29 April 2020

Our Ref: P-20107 | CD

RE: SSD-7874 | HARBOURSIDE SHOPPING CENTRE REDEVELOPMENT

Image 77 View sharing analysis (50 Murray Street) for 3 tower options **(Indicative analysis only for comparison purposes)**

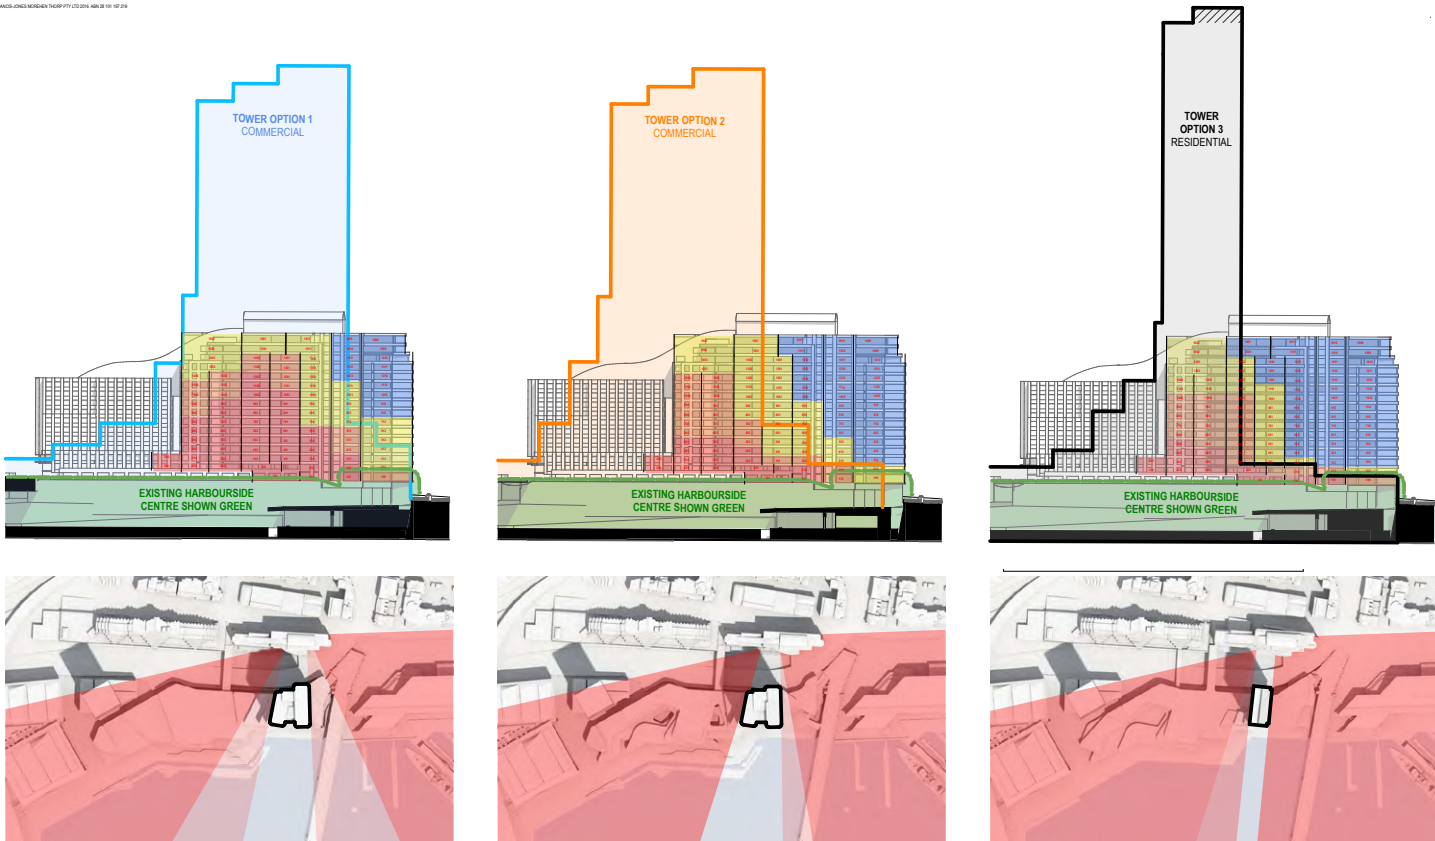
As a result of repositioning the proposal's tower towards the southern end of the subject site, views of the city skyline from the hotel suites will be devastated, particularly for those suites within the Novotel Hotel. The proponent's view sharing analysis at page 40 of its Architectural Design Report, and page 30 of its Visual and View Impact Analysis, acknowledge this. Figure 2 is an extract of the proponent's Architectural Design Report demonstrating the likely view impacts from the Novotel Hotel.

In our opinion, the impacts are worse than anticipated by the proponent's revised analysis, as it does not consider the cumulative impacts associated with the recently constructed Sofitel. With the proposed tower being located further south of the subject site, and the existing Sofitel tower to the south of the Novotel Hotel, views from the Novotel Hotel become 'boxed' and narrow. Figure 3 below, taken from level 9 of the Novotel Hotel, demonstrates this likely outcome with the existing Sofitel Hotel along the right-side edge of the photograph.

- Reposition the tower towards the centre of the subject site. This is likely to achieve greater sharing of views between the Novotel Hotel, the Ibis Hotel, and 50 Darling Street. Given the economic and cultural contributions such hotels provide, they warrant access to views in accordance with established view sharing principles. This position is not likely to result in adverse heritage impacts to the Pyrmont Bridge.
